October 26, 2022

**Re: Project no. PR-2022-007701, Application no. SI-2022- 01868
New Branch office for Nusenda Credit Union at 2801 Juan Tabo NE, Abq NM.**

The following are responses describing how we comply or are addressing staff comments to follow IDO and other requirements for site plan approval:

Landscape
Plan

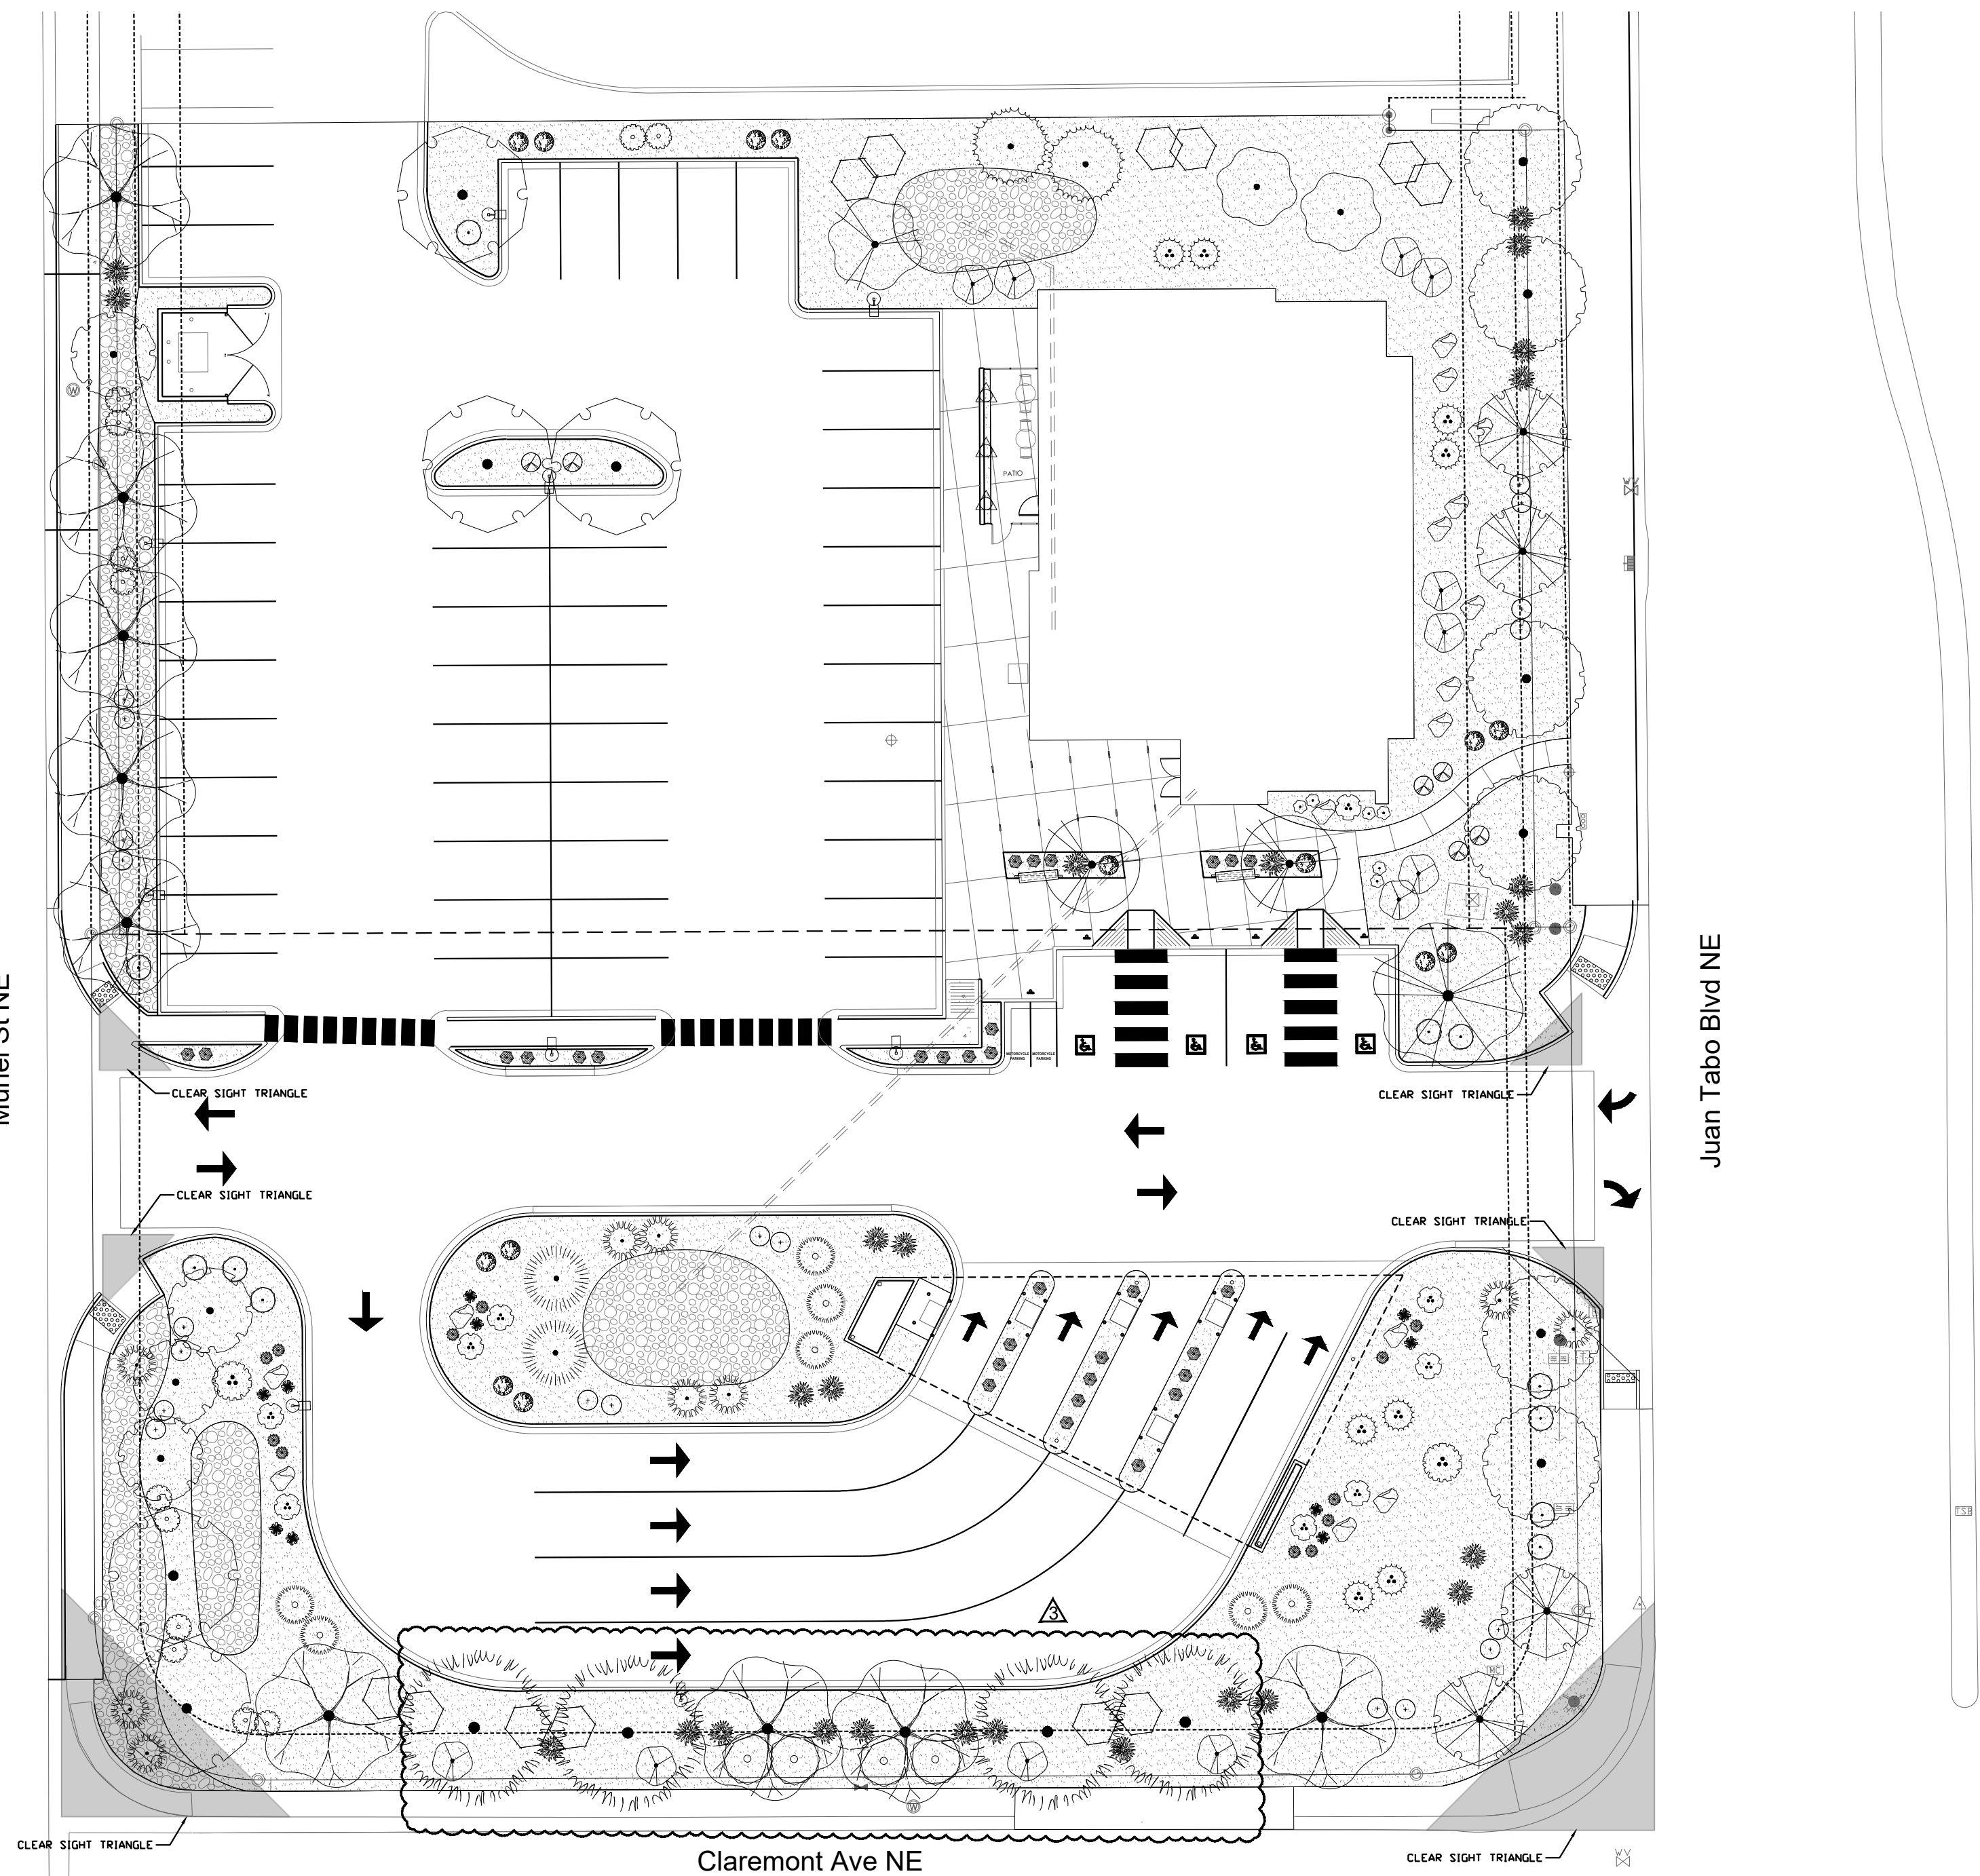
1. 20 shrubs and 10 street trees are shown on the landscape plan at the south property line. These are in a landscape buffer that is 15' wide. It is our position that the shrubs and trees, once mature will provide adequate screening.
2. A note has been added to detail 3/A002 to comply with all night sky ordinances and IDO 5-8 requirements. (attached)

ELEVATIONS

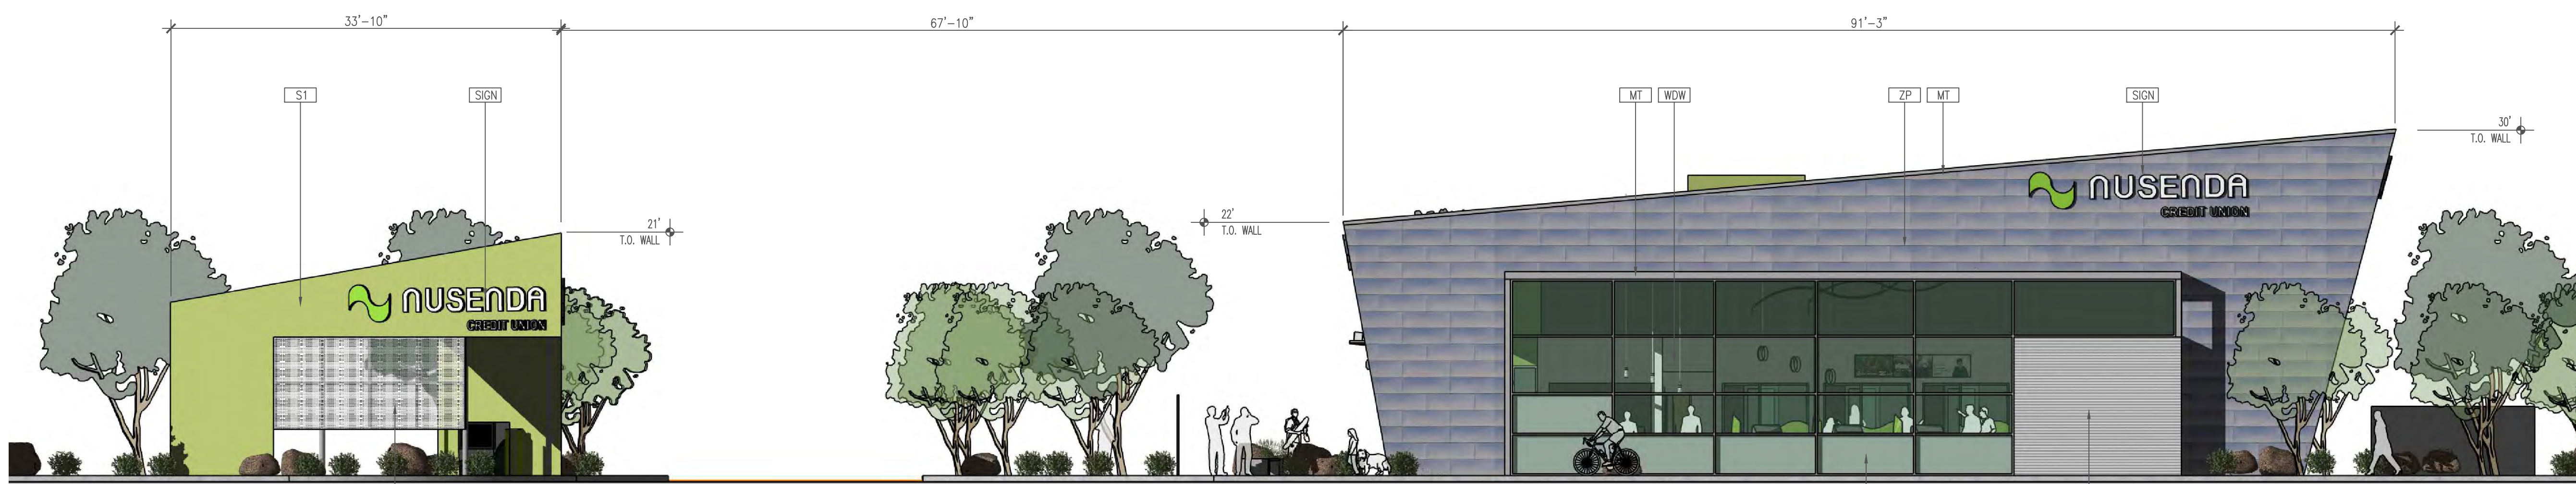
c. 5-5. Table 5-5-1, Parking requirements and calculations are shown on the site plan.
5-6. Landscape calculations are in compliance and shown on the landscape plan. The mechanical screens on the roof are shown on the elevations.
5-7. Separate permits for fences. Acknowledged.
5-8. A note has been added to detail 3/A002 to comply with all night sky ordinances and IDO 5-8 requirements. (attached)
5-11. The elevations show that the project meets and exceeds the development standards as listed in 5-11. I am attaching some model views to further explain this.
5-12. The signs as shown on the elevations are in compliance with IDO 5-12 as they pertain to MX-L.
